I have reviewed the Application for the Denmark Heights Short Plat (SP-07-109). The area for this proposed short plat is over 5 miles from the nearest staffed fire station and is subject to extended fire and emergency medical service response time. This information is provided for informational purposes to the developer. There are no restrictions to rezoning the property from the perspective of Kittitas Valley Fire and Rescue. During development, the following issues will need to be addressed:

TO: Mike Elkins, Staff Planner, Community Development Services  
FROM: Randy Carbary, Planner II *RC*  
DATE: September 7, 2007  
SUBJECT: Denmark Heights Short Plat

Our department has reviewed the Short Plat application and has the following comments:

**DENMARK HEIGHTS SHORT PLAT**  
**PART OF SECTION 27, T. 17 N., R. 19 E., W.M.**  
**KITTITAS COUNTY, WASHINGTON**

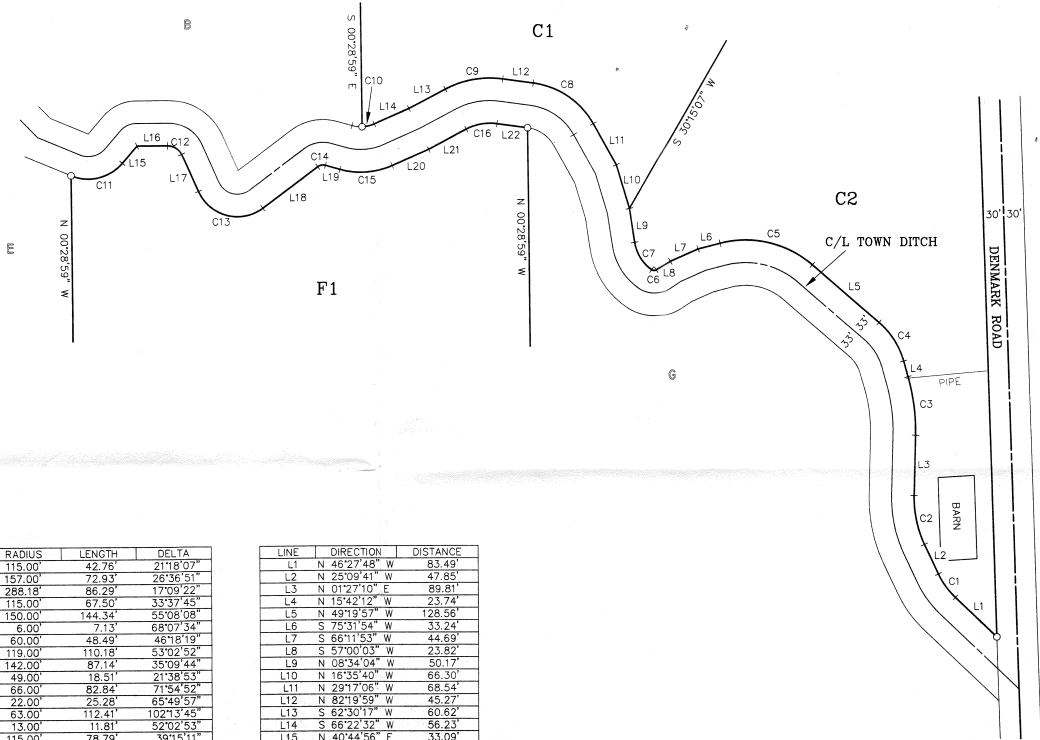
2. Private Road Improvements: Access for Lots C1 and C2 shall be via the proposed 60' access easement, as shown on the face of the preliminary plat. Access shall be constructed as a Low-Density Private Road. See Kittitas County Road Standards, 9/6/05 edition.

3. Cul-de-Sac for Existing Road: Since the access for lots C1 and C2 serves 3 or more lots, a cul-de-sac shall be required at or near the northwest corner of lot C1. Permanent dead-end streets shall have a turn-around having an outside right-of-way easement diameter of at least 110' (55' radius) at the closed end. See Kittitas County Road Standards, 9/6/05 edition.

- a. Cul-de-sac design, reference AASHTO.
  - b. Contact the Fire Marshall regarding any additional cul-de-sac requirements.
4. Access Spacing: Access for lots F1 and F2 is being proposed via the 30' access easement, as shown on the face of the preliminary plat. However, the proposed access location does not appear to meet the minimum access spacing required by current Kittitas County Road Standards. Thrall Road is classified as a Rural Major Collector with a posted speed limit of 50 mph. Current Kittitas County Road Standards requires a minimum access spacing of 1,000' between access locations. The proposed access appears to be less than 800' from the Denmark Road intersection. The applicant can propose a different access location, further west, as long as adequate sight distance can be achieved. The applicant shall propose an access location that can meet or exceed the county's minimum design standards for access spacing and for a joint-use driveway as described below.
